**Consultation Response from KC,
Conservation & Design**

2025/92440 Lumb Lane Nurseries, Lumb Lane, Almondbury, Huddersfield, HD4 6SZ

Erection of five dwellings

Date Responded: 21/11/25

Above: Proposed Site Layout

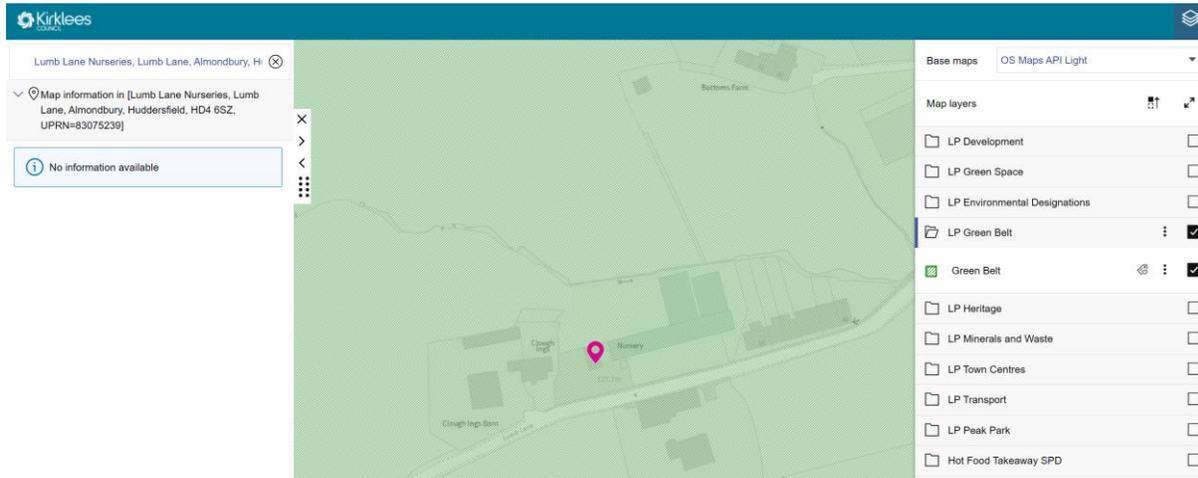
In terms of siting, both the terraces and detached house could be slightly brought forward, subject to achieving Highways visibility requirements. If the buildings could be brought forward slightly but still set back from existing buildings, there would be space for more landscaping at the rear/north to soften the appearance within the setting of the Castle Hill landscape setting. The use of appropriate native landscaping throughout the site would assist with improving the setting of the new buildings.

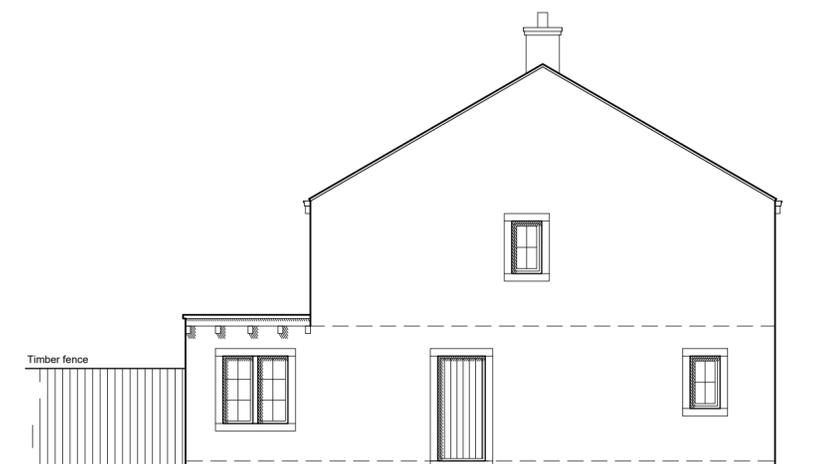
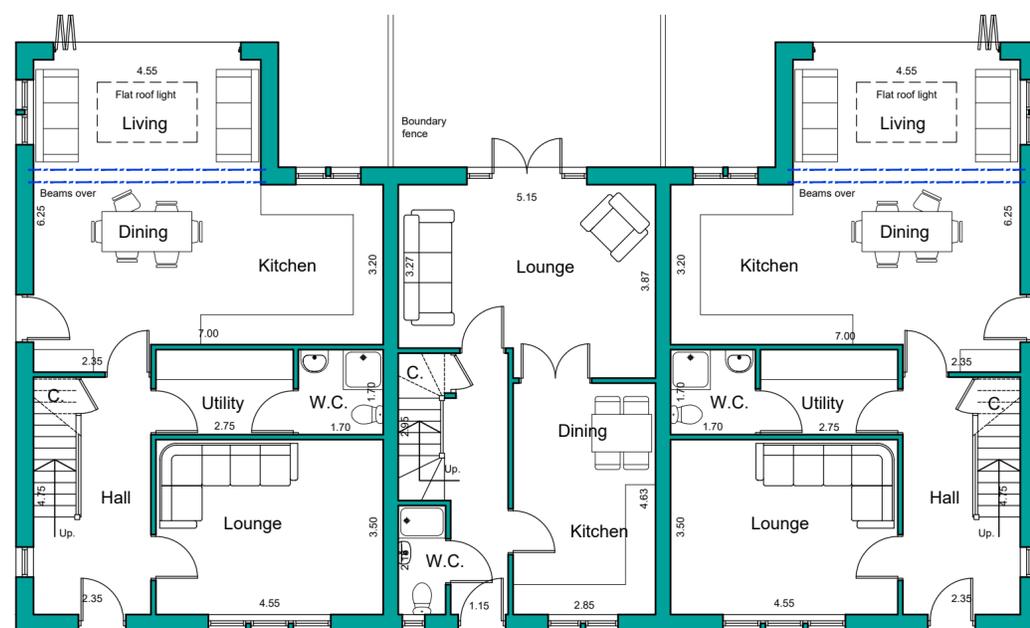
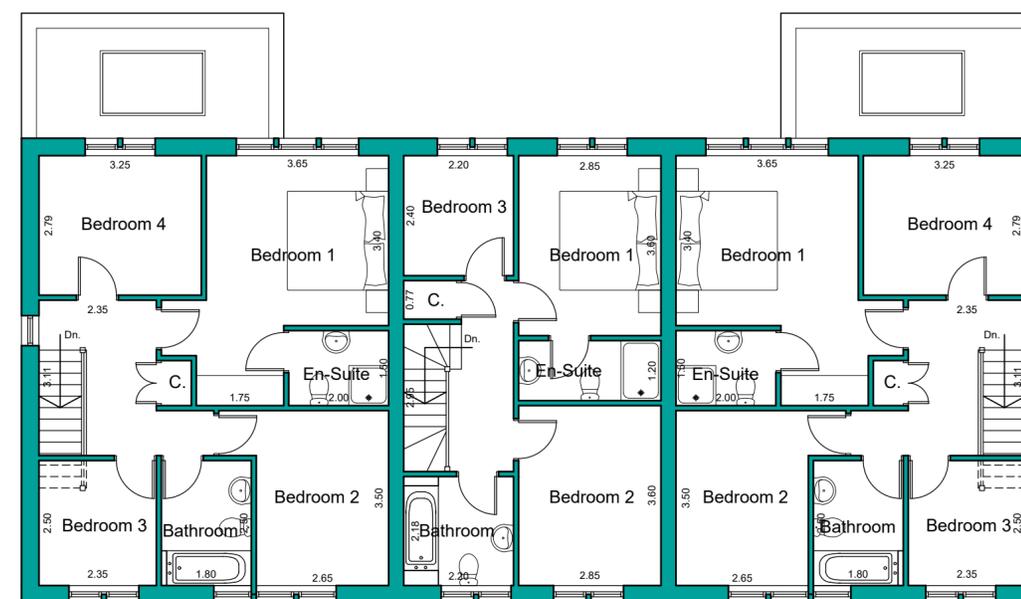
The revision to propose 3 terraces adjacent to the existing listed terraces appears more appropriate in terms of scale and design. The single detached house adjacent to the existing unlisted detached house could be acceptable subject to a reduction in size, scale and massing. The rear extension for office/games room appears disproportionately long and should be reduced in size.
